Online Comment

Application H16-0209-25
Location THE SESSIONS HOUSE SHEEP MARKET SPALDING PE11 1BB
Proposal Removal of tiered benching viewing gallery in the old courtroom

Historic Environment Officer

PROJECT TITLE Proposed Removal of Tiered Viewing Gallery	CLIENT Castle Events Ltd, The Sessions House, Sheep Market, Spalding	CHK BY ---	DRAWN BY CLA
DRAWING STAGE Planning	SCALE 1:50 @ A1	STAGE PLN	REV D
SHEET TITLE Removal Plan	PROJECT NUMBER PE11-4138	SHT 002

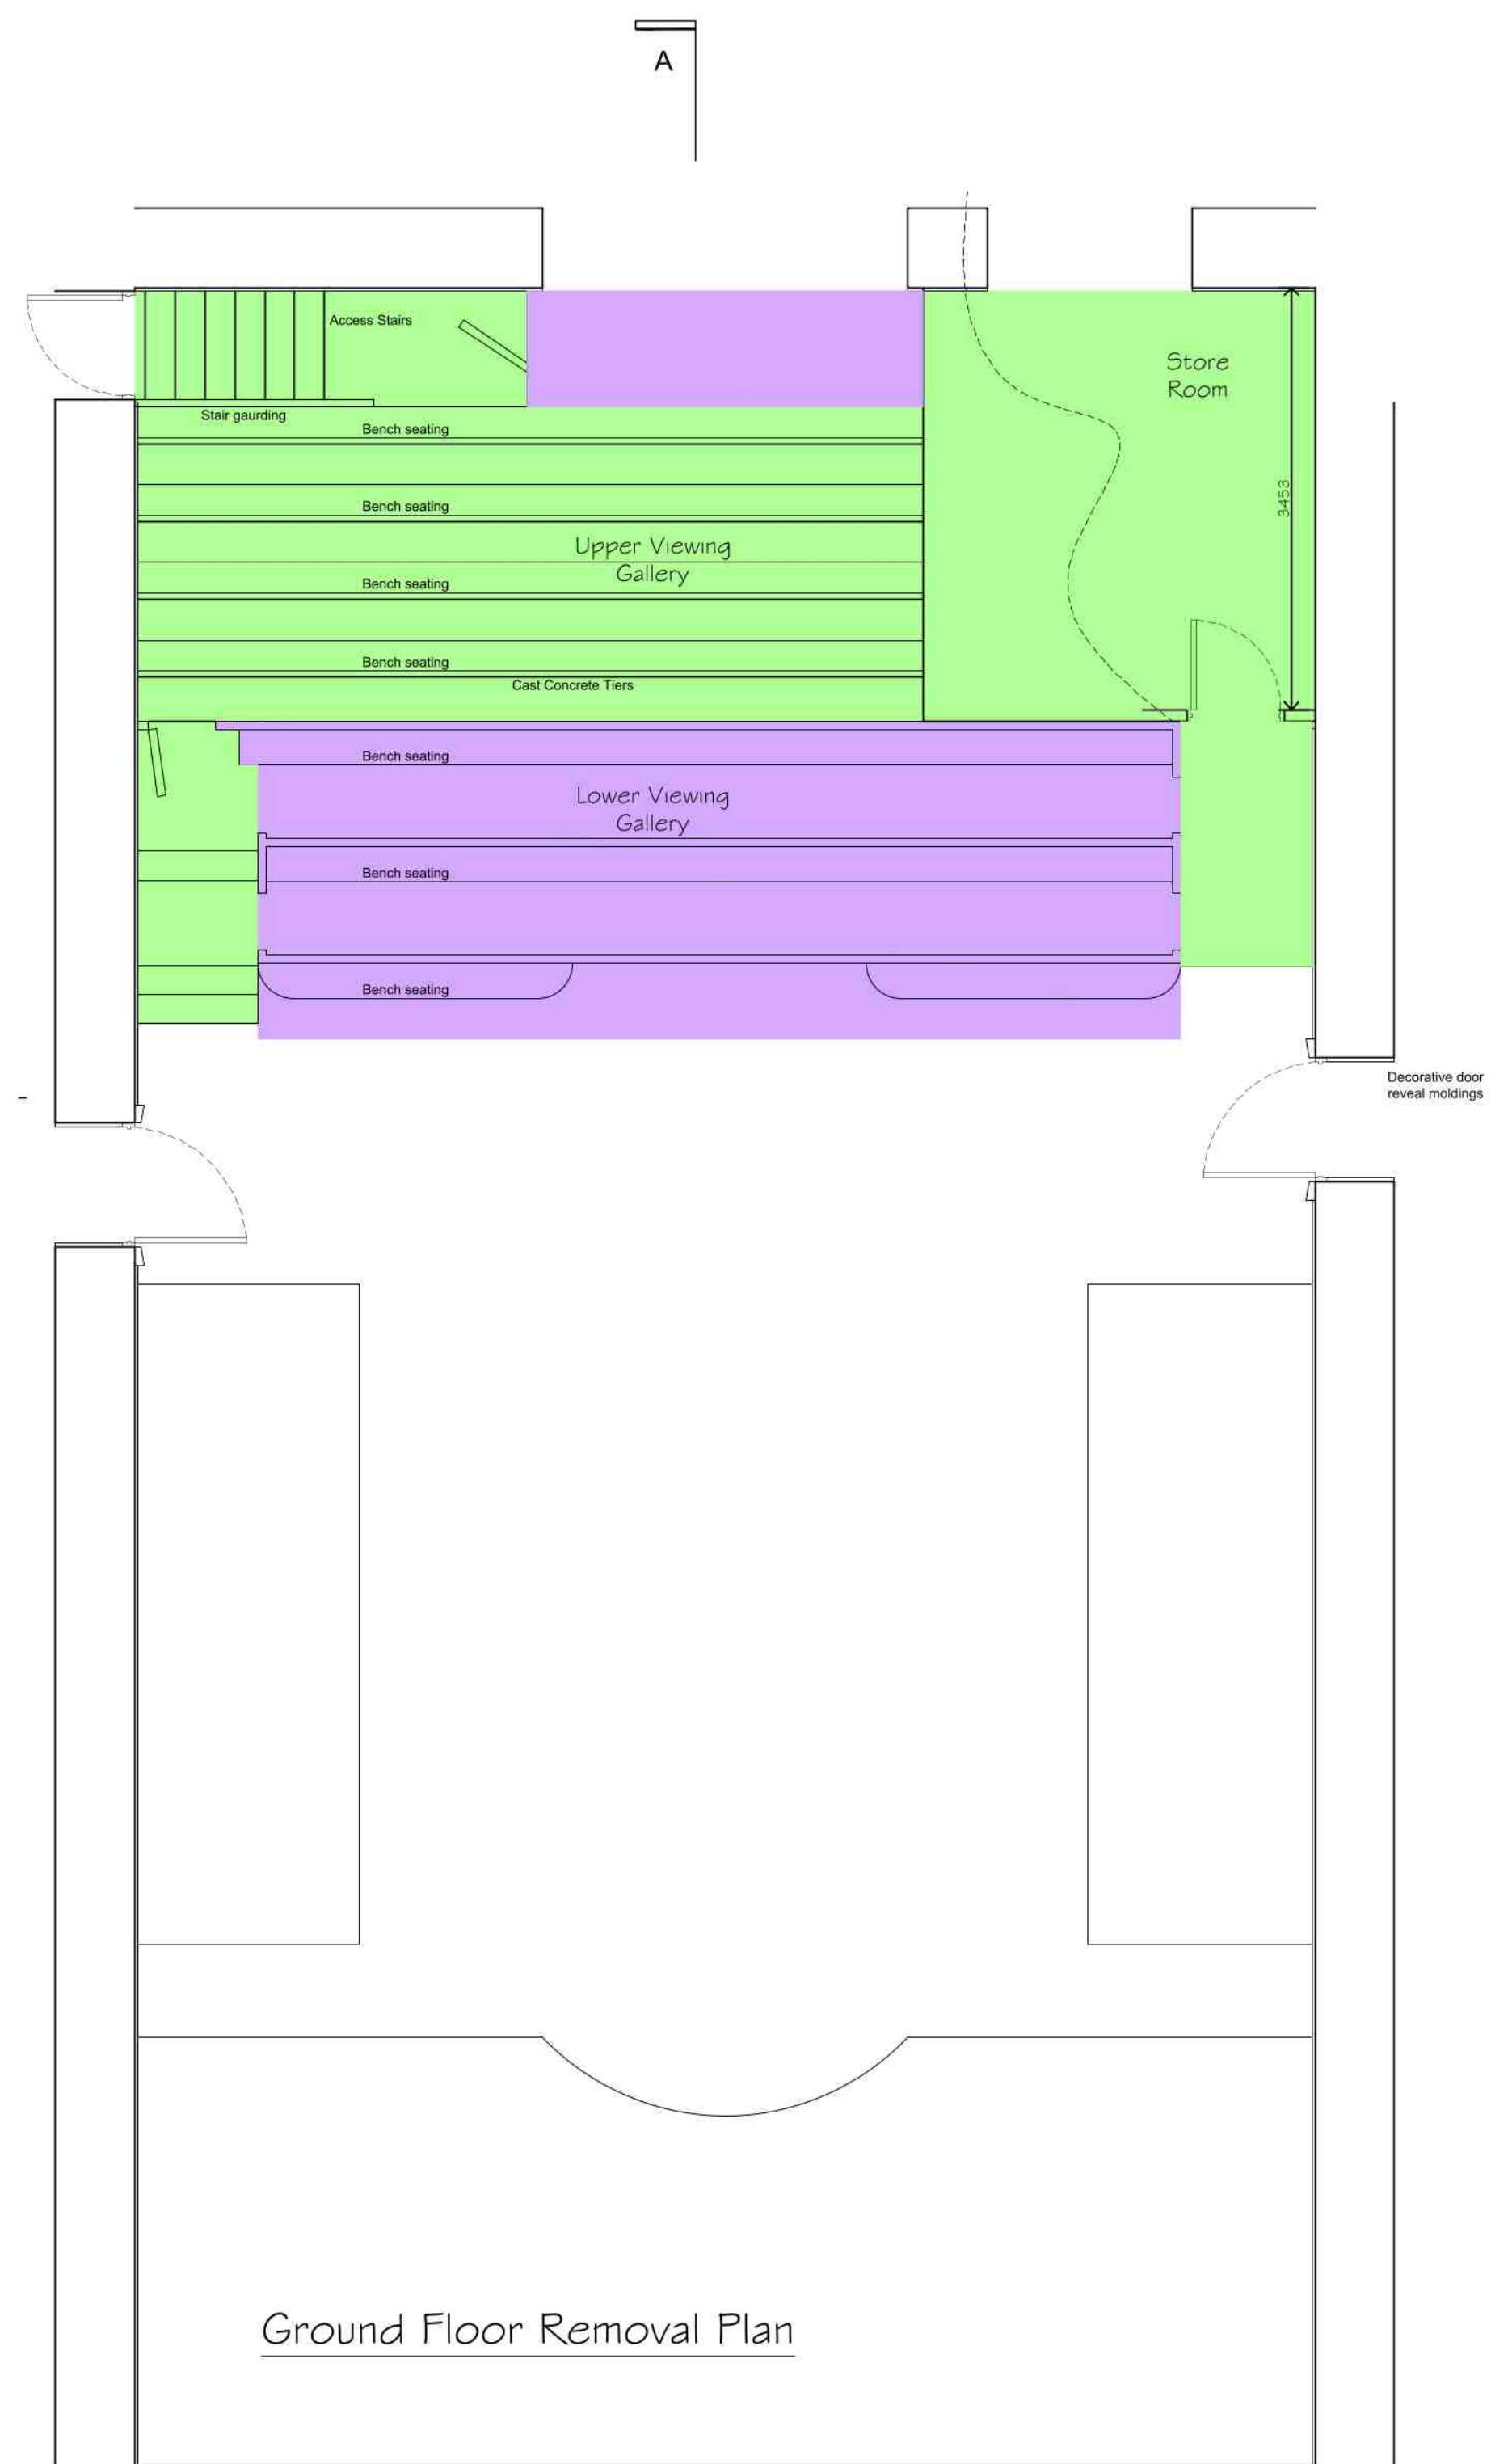
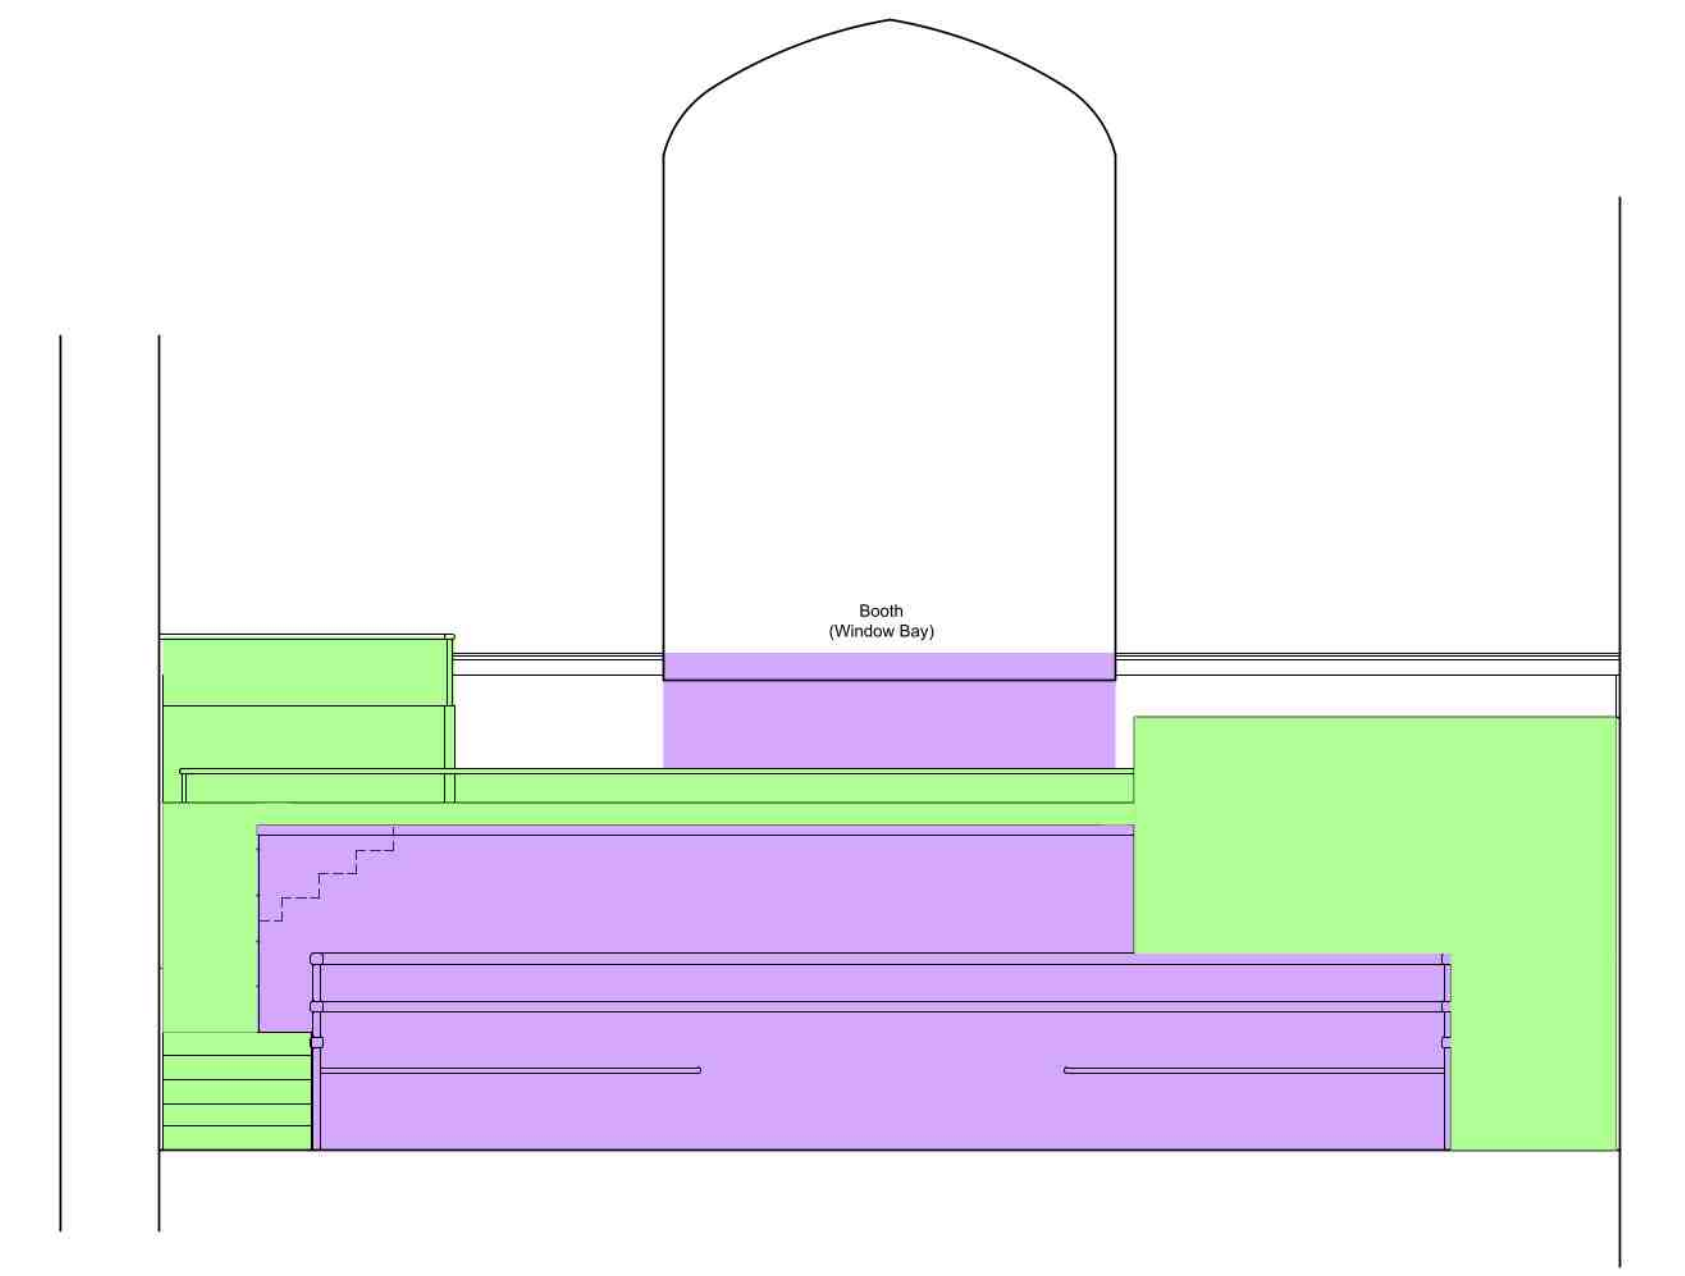
The proposal includes the 'remove the tiered benching veiwing gallery in the old courtroom of Session House'. The complete removal of the C10th benches would harm the building's significance and affect its historic interest.

Therefore, we are unable to provide an informed recommendation on the application until the applicant has provided a more detailed assessment of the proposal's impact on the listed building. This should include an exploration of partial retention options and details on the storage of the benches. A revised heritage impact assessment will be required.
